DRB	Application No.: 08DRB-70134 Project # 1006819
Proje	ect Name: SOUTH BROADWAY ACRES UNIT 1
Age	nt: THOMPSON ENGINEERING CONSULT\ Phone No.:271-2199
follo	request was approved on <u>3/19/08</u> by the DRB with delegation of signature(s) to the wing departments.  STANDING SIGNATURES COMMENTS TO BE ADDRESSED
30/00	TRANSPORTATION: Conneds
	WHW - 6
	UTILITIES:
<b>#</b>	CITY ENGINEER / AMAFCA: 57/1
	PARKS / CIP:
	PLANNING (Last to sign):
	Planning must record this plat. Please submit the following items:  -The original plat and a mylar copy for the County Clerk.  -Tax certificate from the County Treasurer.  -Recording fee (checks payable to the County Clerk). RECORDED DATE:  -Tax printout from the County Assessor.  3 copies of the approved site plan. Include all pages.  County Treasurer's signature must be obtained prior to the recording of the plat with the County Clerk.  Property Management's signature must be obtained prior to Planning Department's signature.  AGIS DXF File approval required.  Copy of recorded plat for Planning.

On December 20, 2007, the Environmental Planning Commission approved Project # 1006819, 07EPC-40047/40076, a sector development plan map amendment and a

PLANTING PLAN

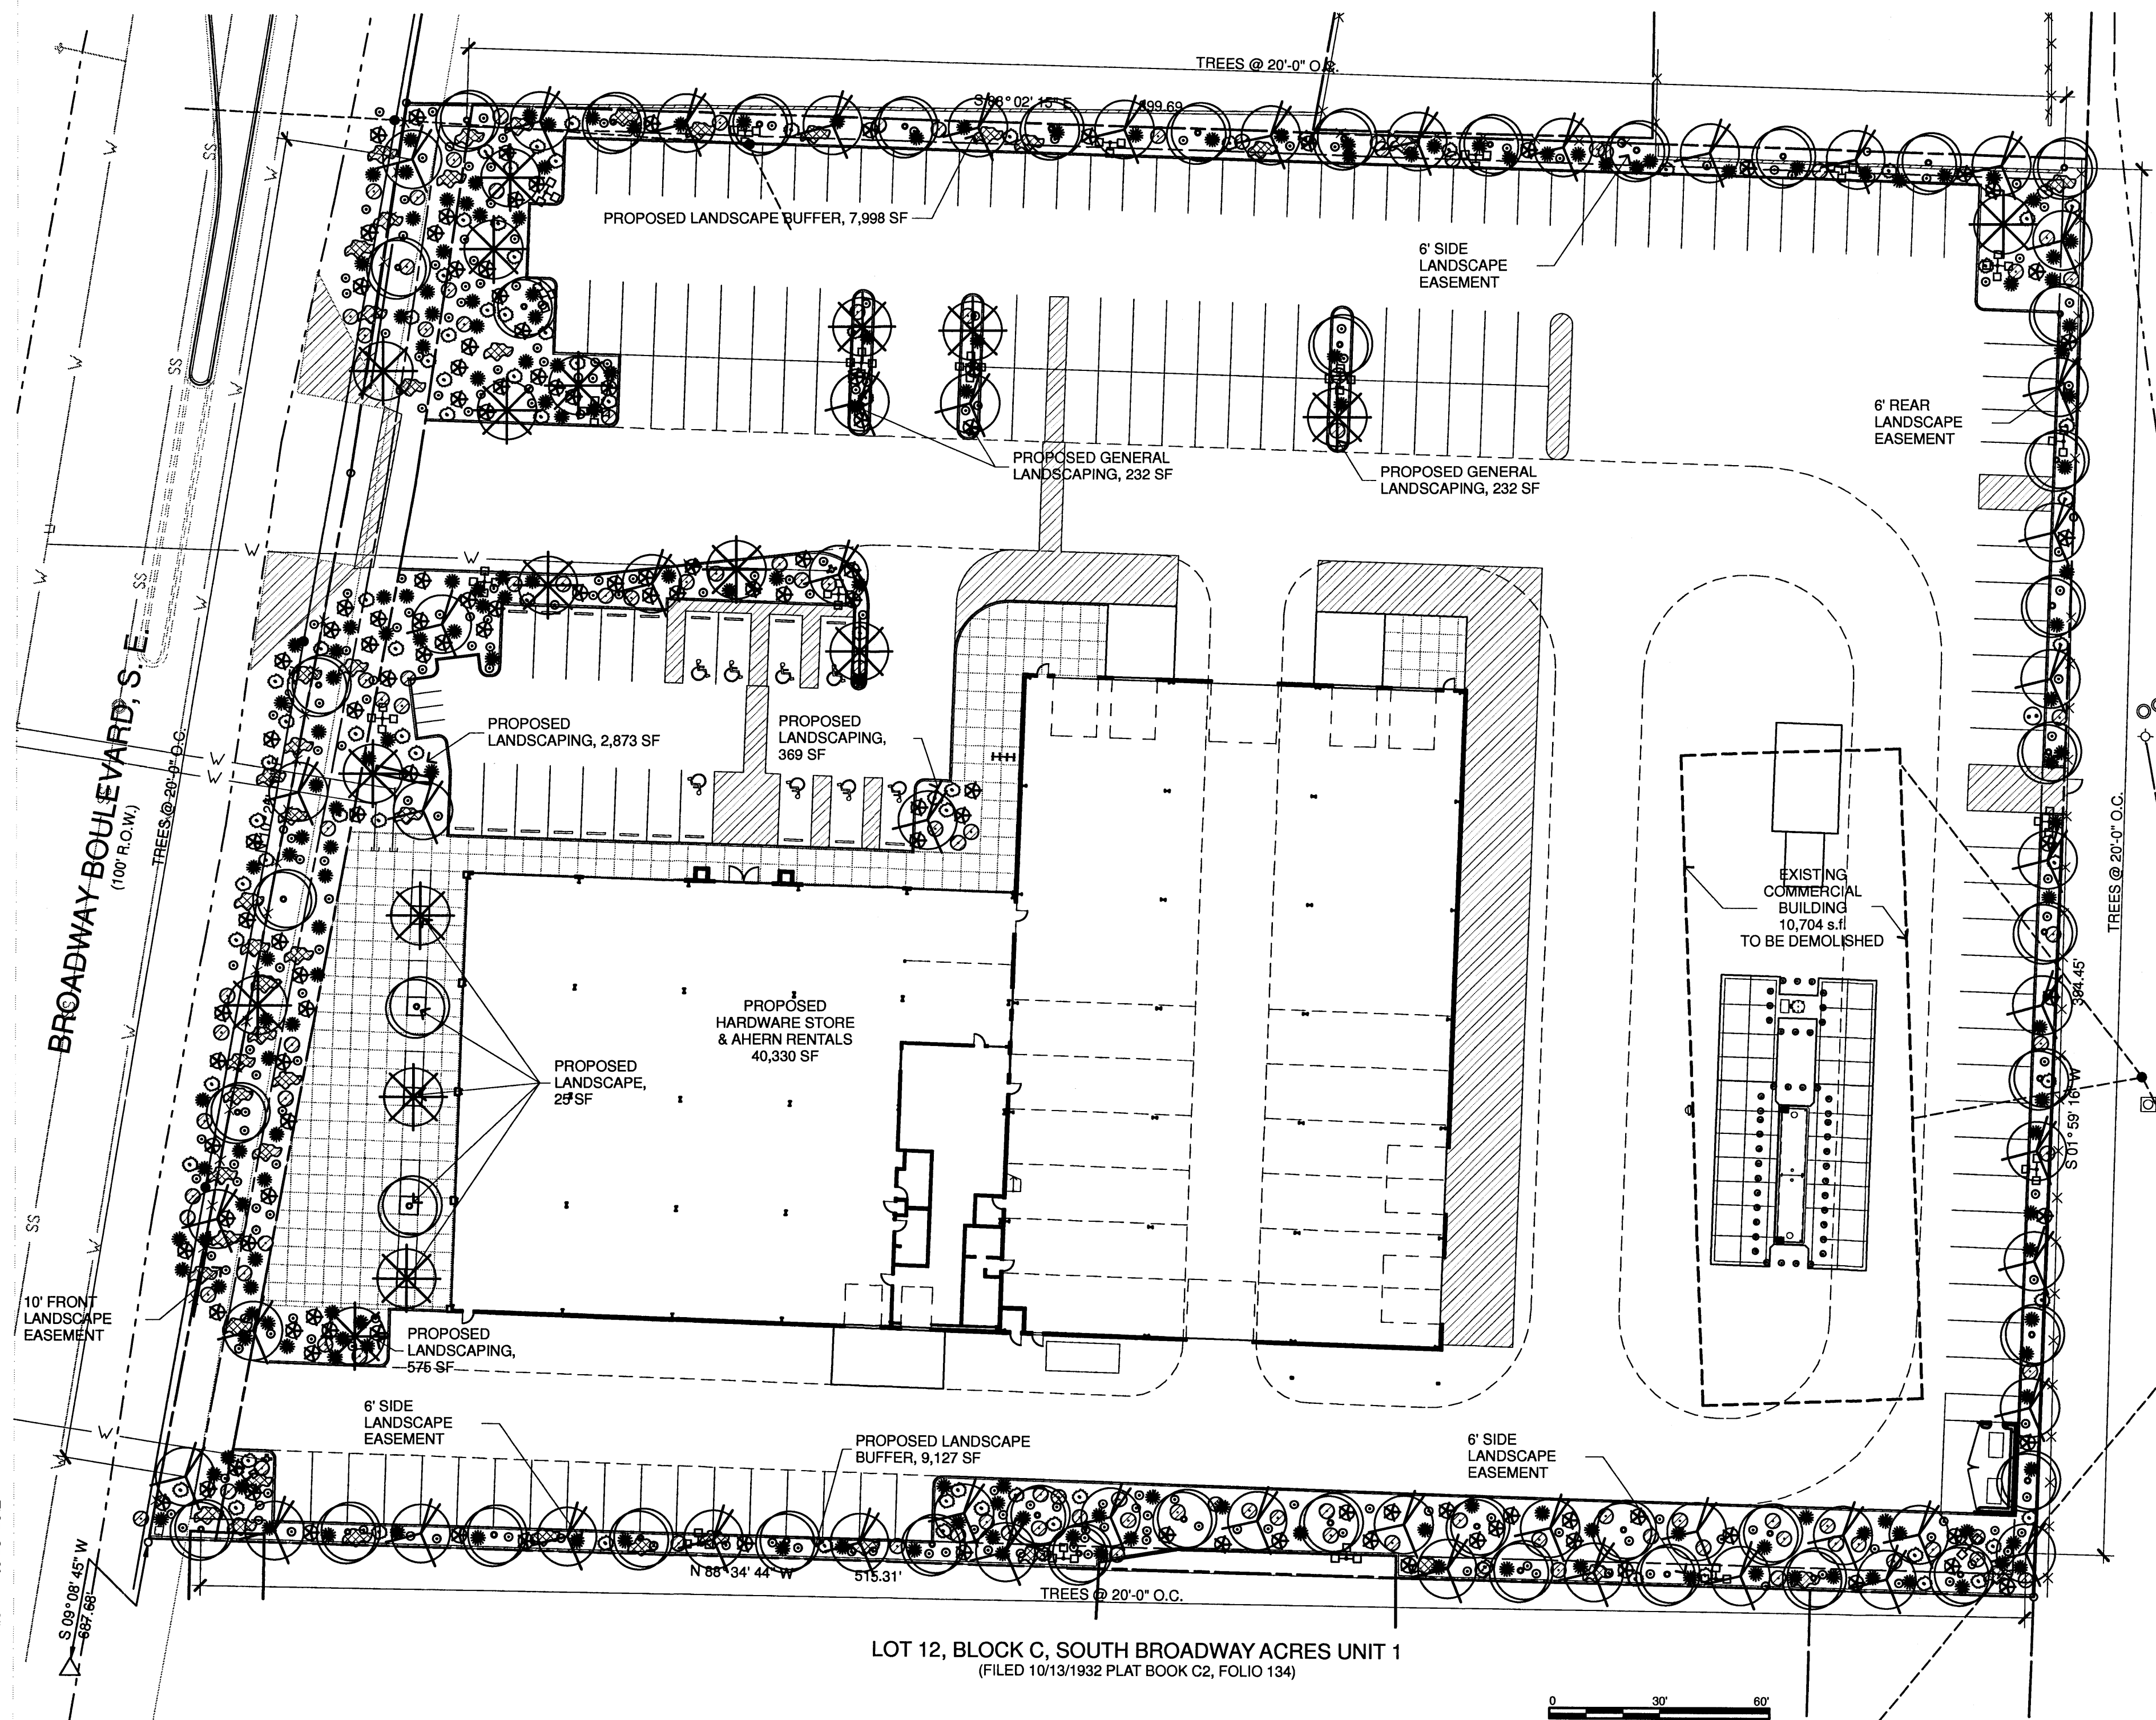
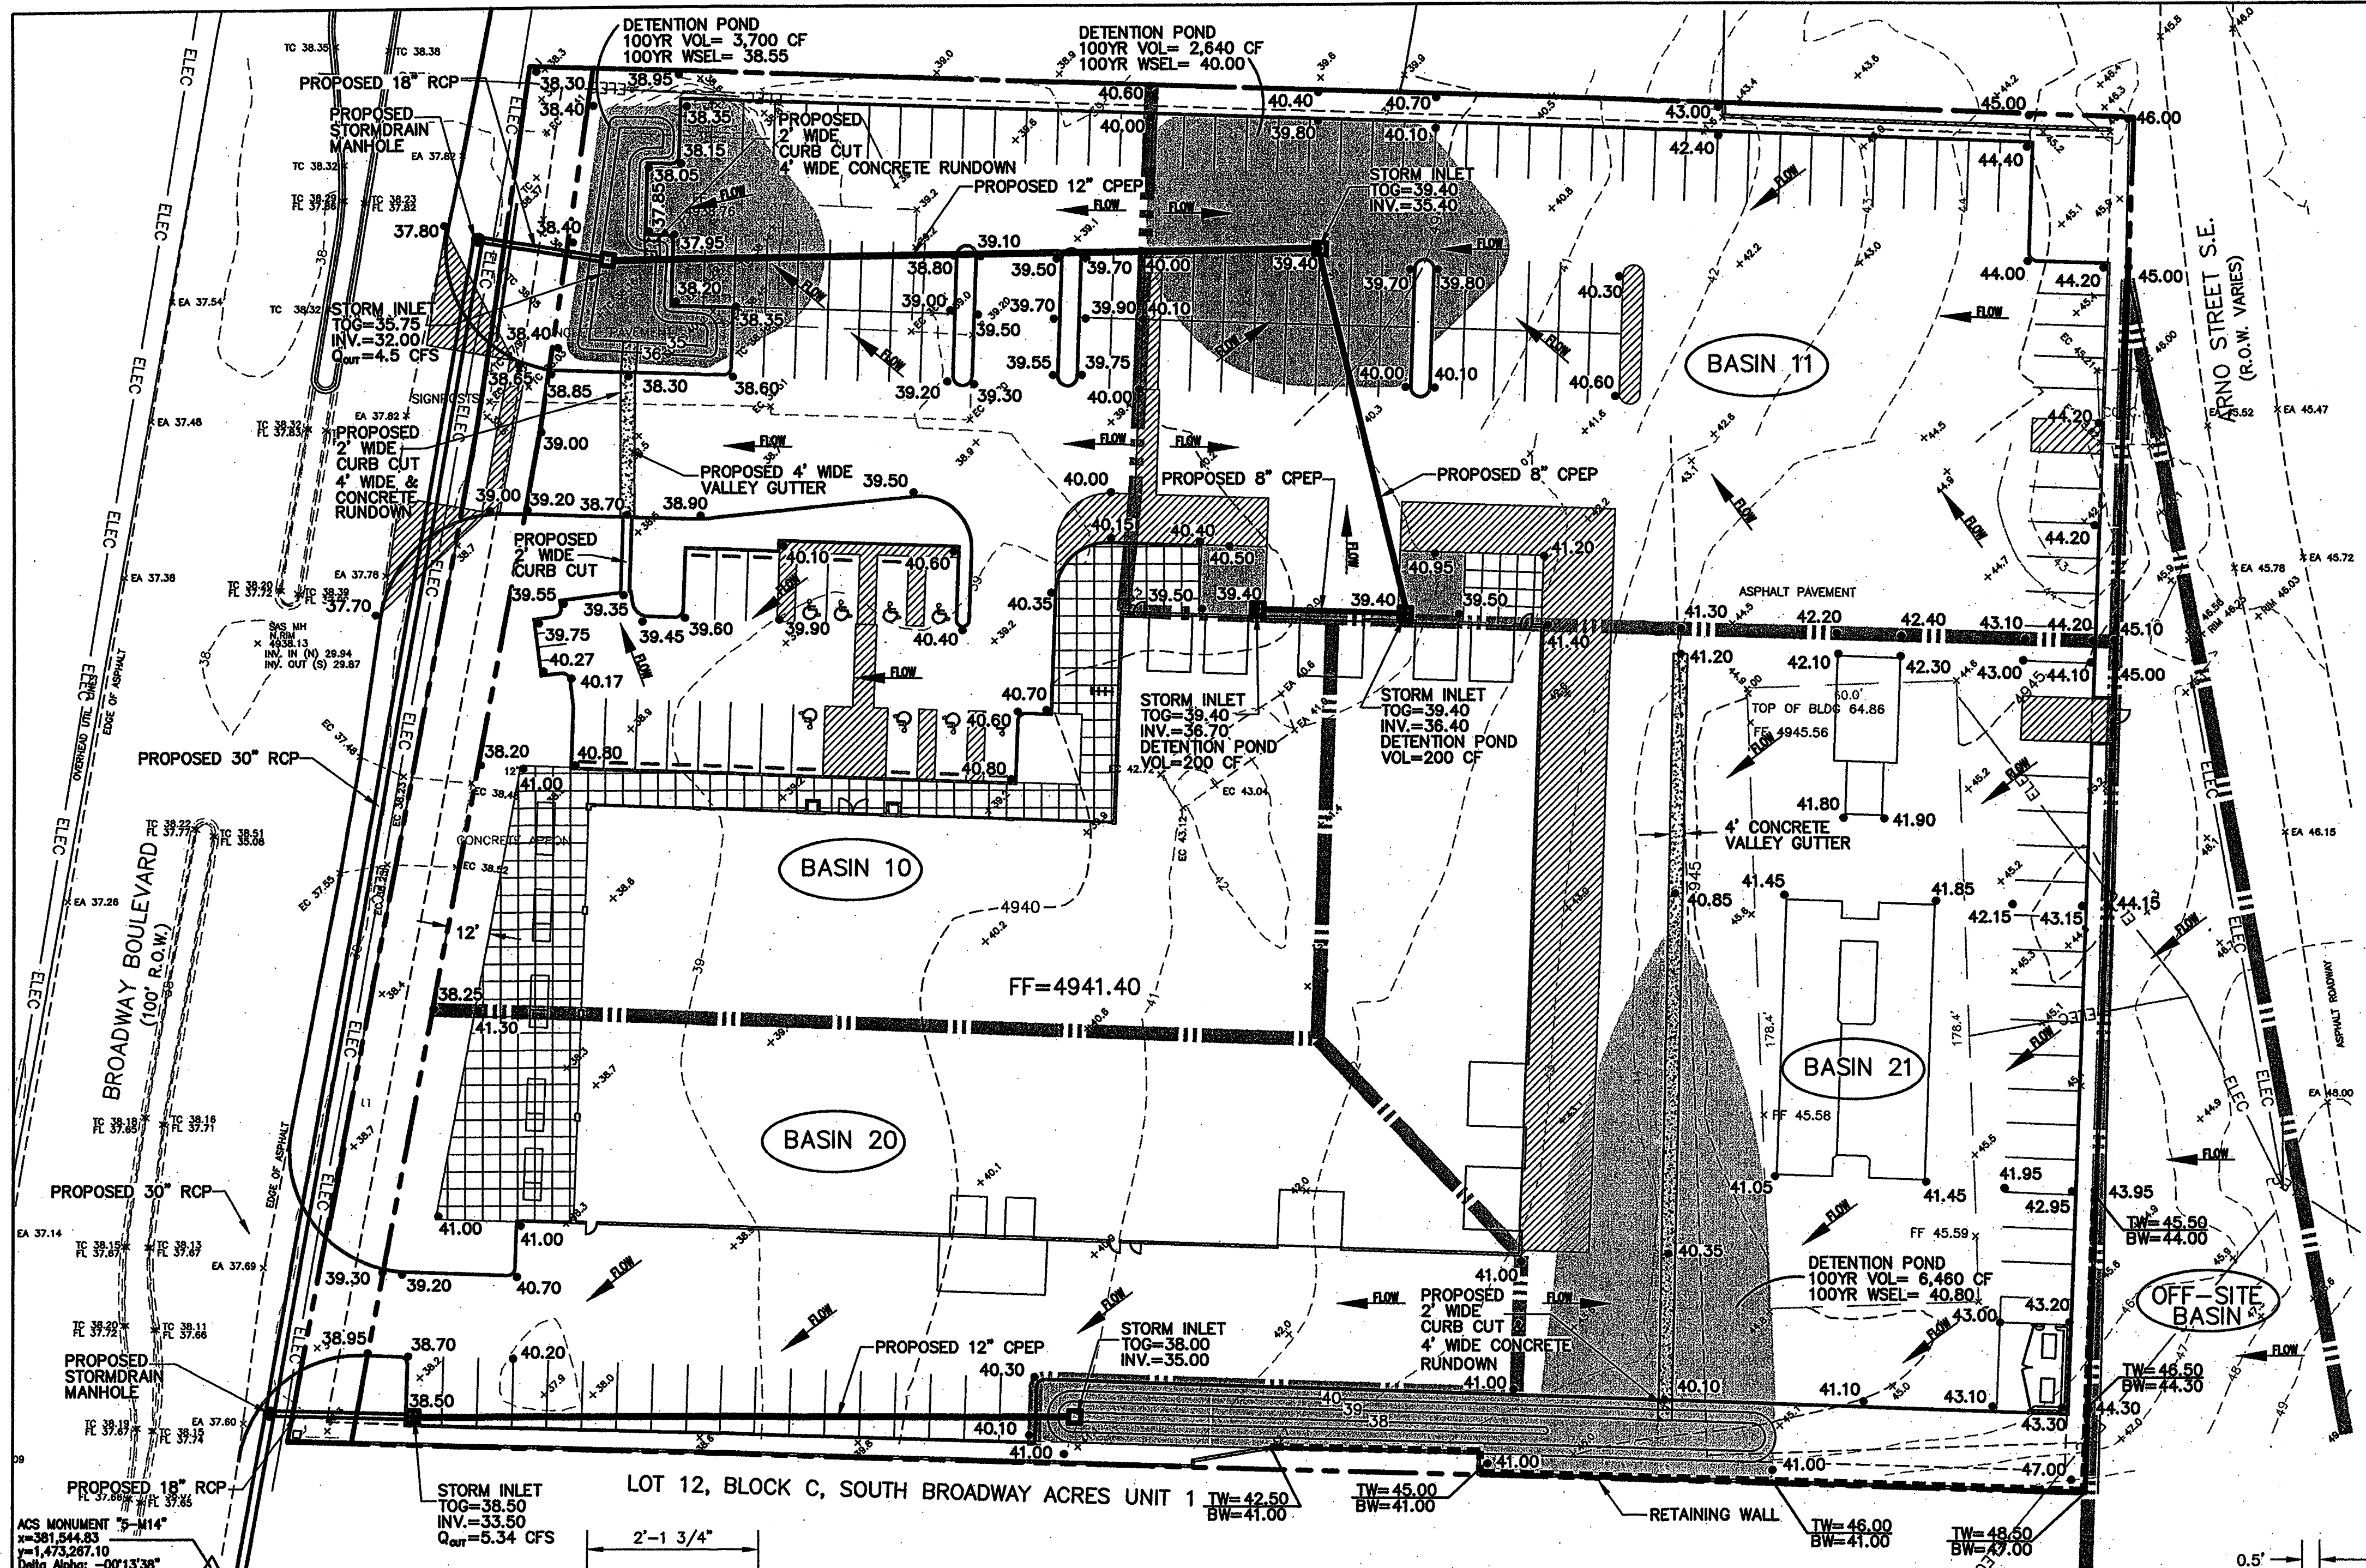
- Item 2. We met with Randall Faulkner and all drawings and revisions have been approved.
- Item 3. The site plan and planting plan have been revised to show the correct alignment of Arno Street.

- Item 7. The description of the light pole has been revised as requested.
- Item 8. The landscaping has been revised.
- Item. 9 The site details have been revised to show the correct height and width.
